**Consultation Response from KC, Conservation & Design**

**2023/90956 rear of, 1, Sparks Road, Oakes, Huddersfield, HD3 4BX**

**Erection of 5 dwellings**

**Date Responded: 2.8.2023**

3. Proposed Site Layout
Scale 1:500

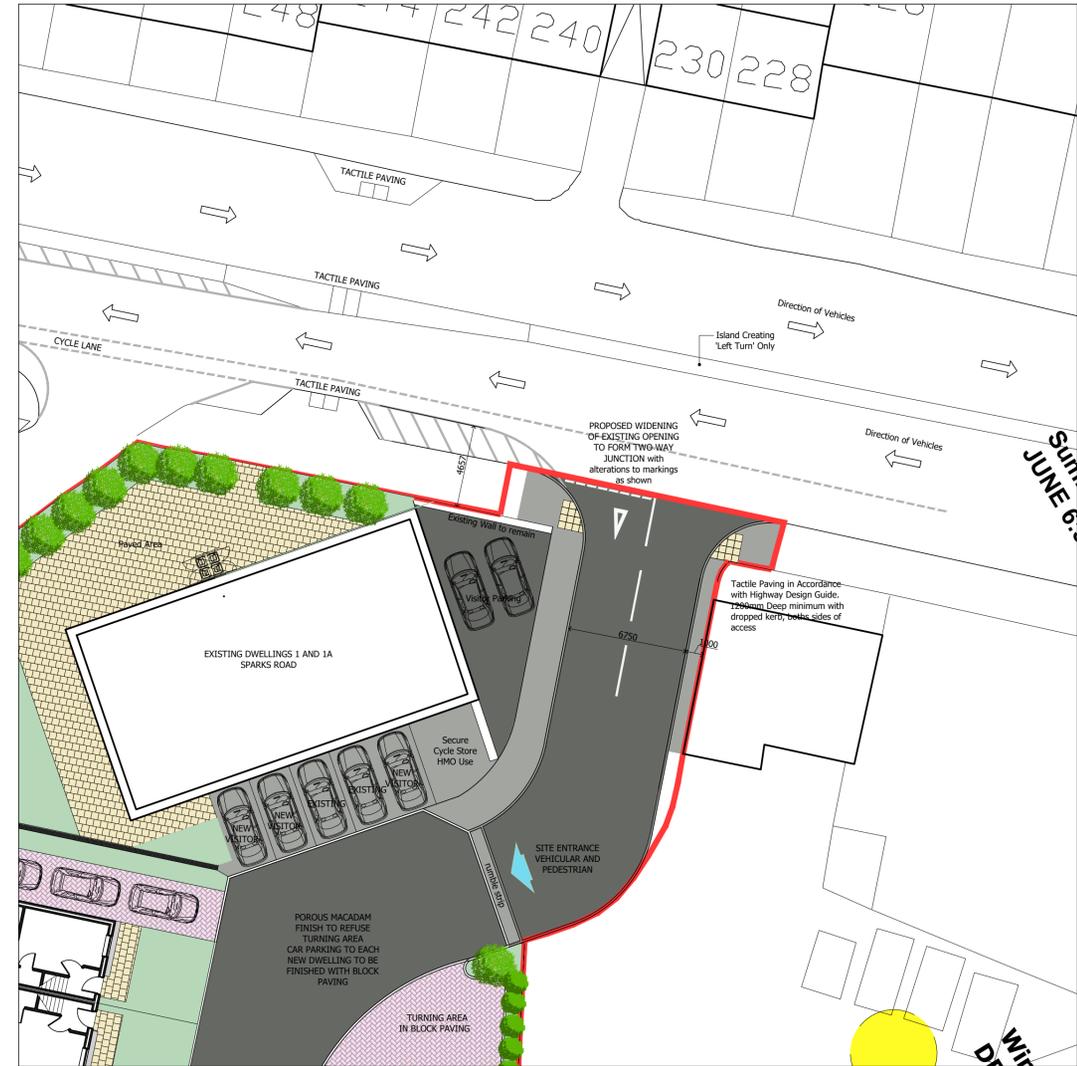
The proposed three-storey townhouses are located around 2m away from the north gable of the listed farmhouse. This group of substantial dwellings will have a significant impact on its setting as they are overbearing, constructed in modern materials and with contemporary detailing such as Juliet balconies and uPVC windows. No sections have been submitted to show the scale of the development in relation to the surrounding buildings. Although less visible from the public highway, the front elevation of the town houses will also harm the setting of the farmhouse, with a substantial elevation dominating the historic farm building and three large garage doors and canopies highly visible in context with it.

To add to the cumulative harm of the proposed development, the two-storey semi-detached dwellings are located on land directly in front of the farmhouse. Although smaller in scale, they are likely to be taller than the farmhouse and will dominate this historic building, eroding its setting and introducing a fairly blank gable end in reconstituted stone directly in front of the curtilage boundary. The use of modern materials and detailing contributes to this harm.
